From: Simon Davis
Sent: 29 May 2019 13:24
To: Planning.Responses
Subject: FW: 0119: P/38/19/PL - Newlands Nursery - Year Round Retention of Seasonal Agricultural Workers Caravans
Attachments: 0119-001-B.pdf; 0119-003.pdf

From: Douglas Briggs Partnership [REDACTED]
Sent: 29 May 2019 13:08
To: Simon Davis [REDACTED]
Subject: 0119: P/38/19/PL - Newlands Nursery - Year Round Retention of Seasonal Agricultural Workers Caravans

Please find enclosed our application plans with the red line amended to include the access as requested.

Site Location Plan
PROPOSED
Feb 2019
0119-001 B
1:2500@A3

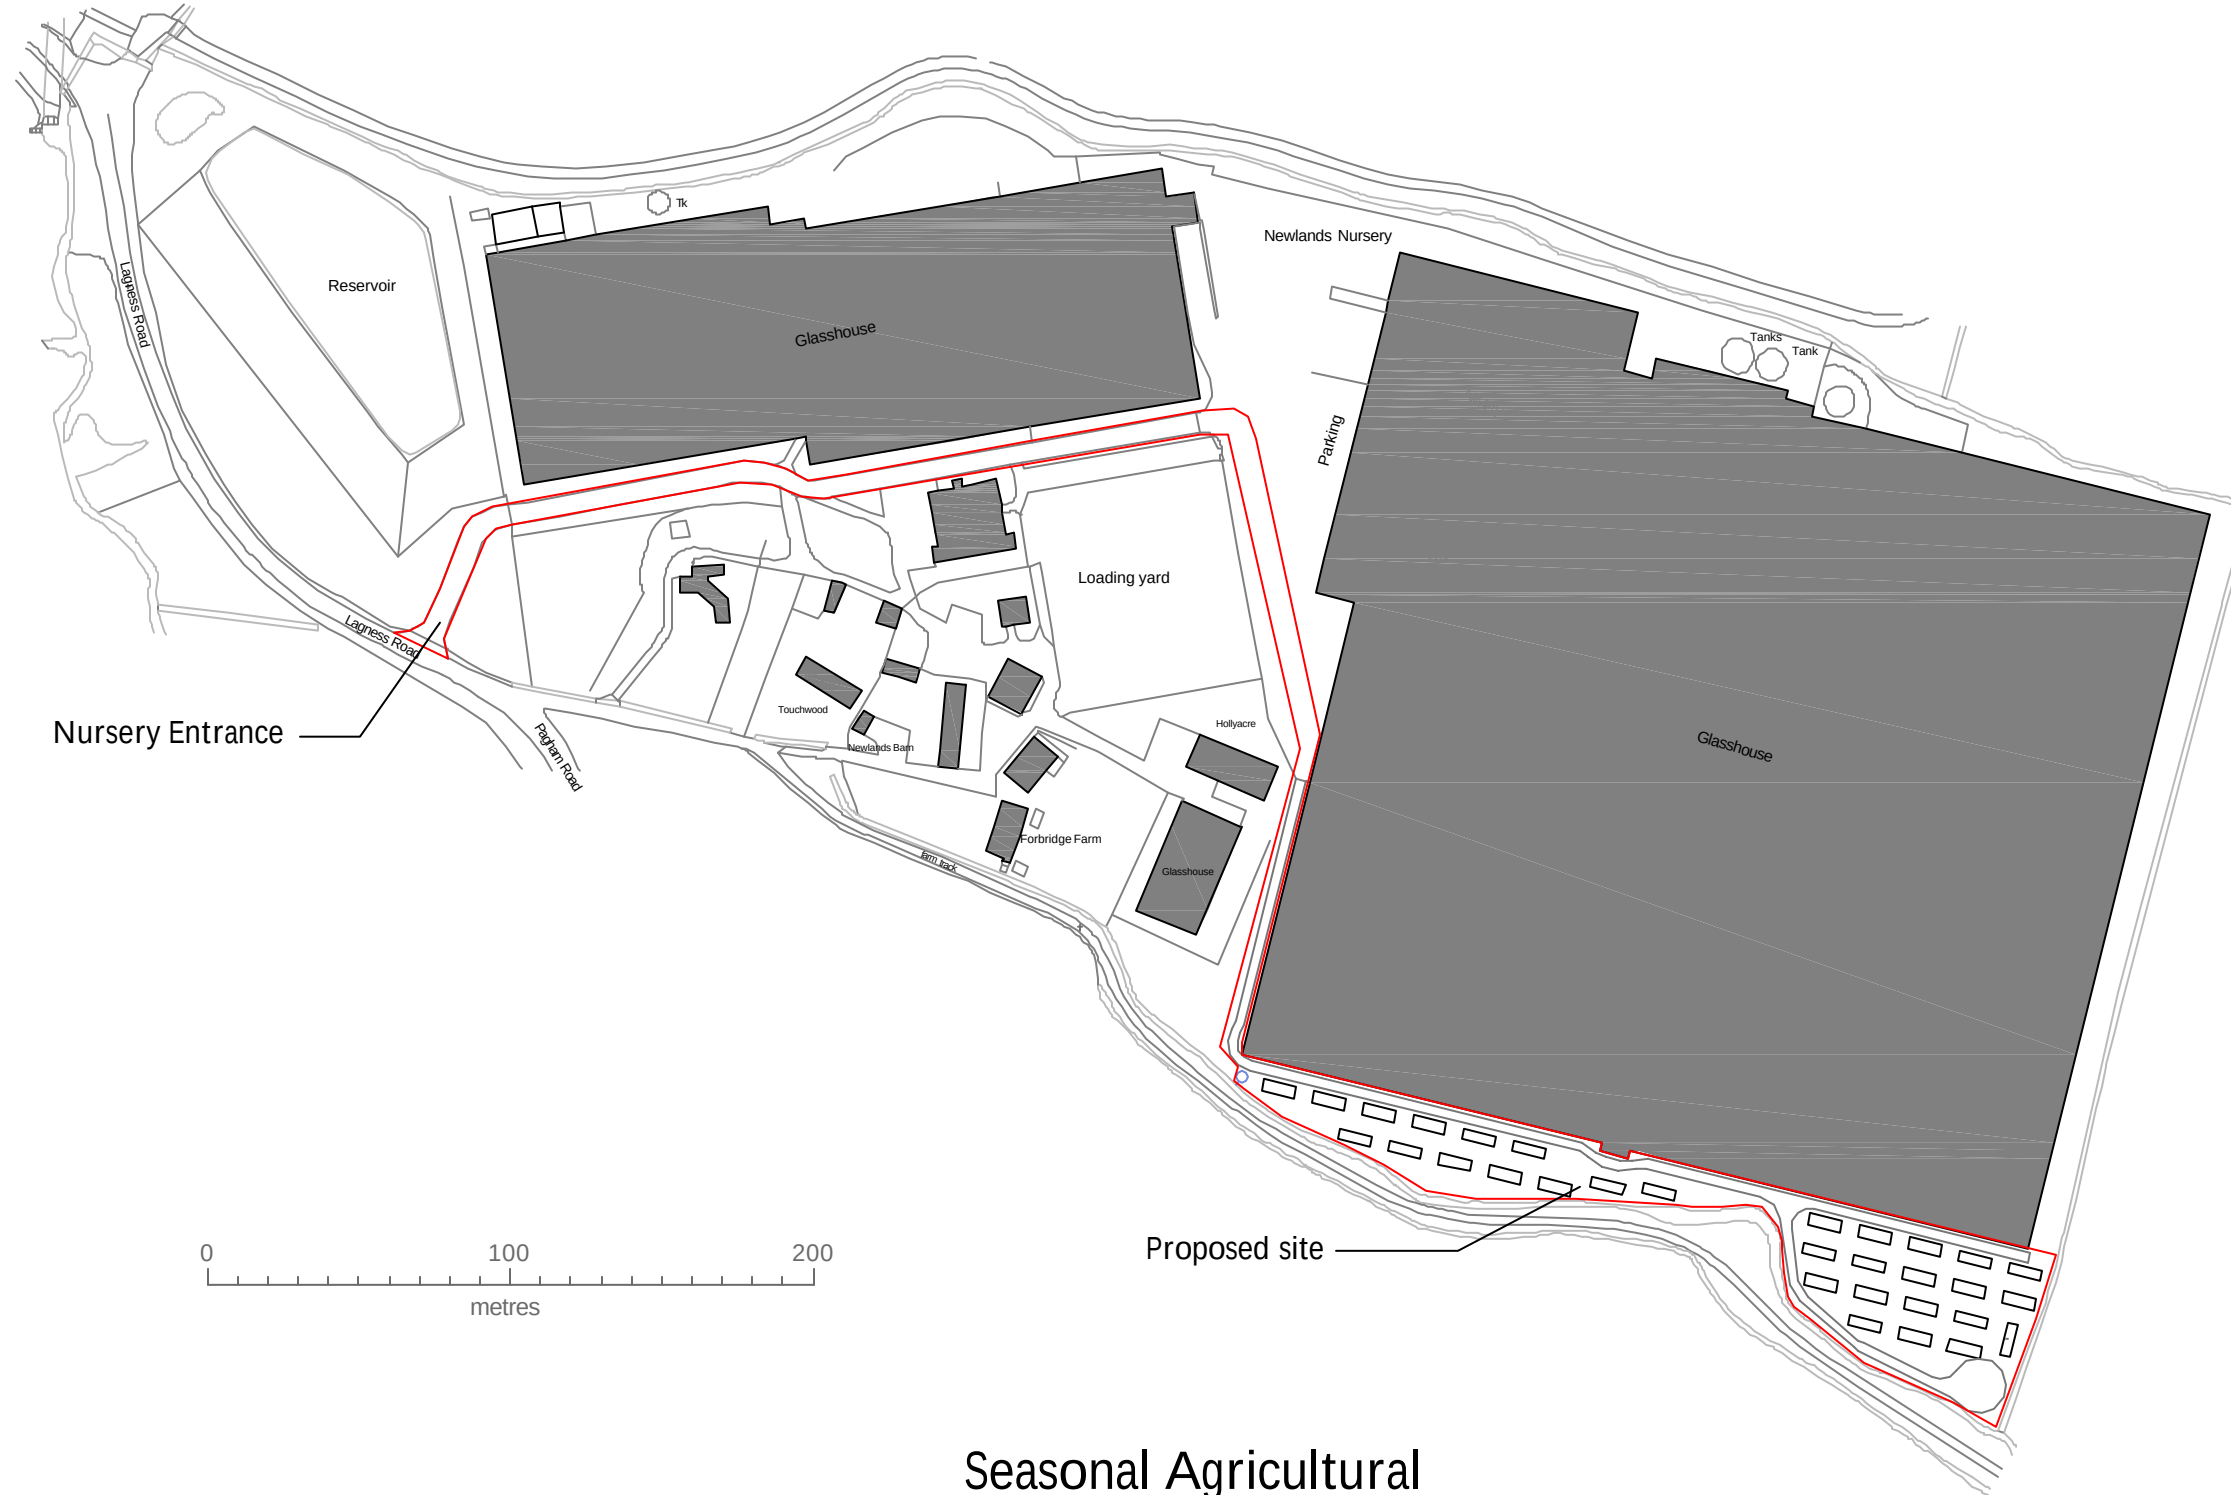
I write separately to my below message. I have a question regarding site ownership. On the location plan, you have only red edged the application site and there is no blue edging. Am I therefore correct in assuming that your clients do not own any other parts of Newlands Nursery? Your Design and Access Statement states that the applicants are part of a parent group that also owns Newlands Nursery...

Furthermore, your red edge on the location plan does not include the access to the highway. I believe this has caused some confusion with residents who think that you will be accessing the site from the private track. The proposed access track which runs around the SW corner of the glasshouses is not clear on the submitted layout plan. It would be helpful if you could amend the submitted red edge to show the access all the way to the highway. We can accept this as an amendment and will not need to reconsult on the changes. However, you may need to serve notice on any other owners of the access route.
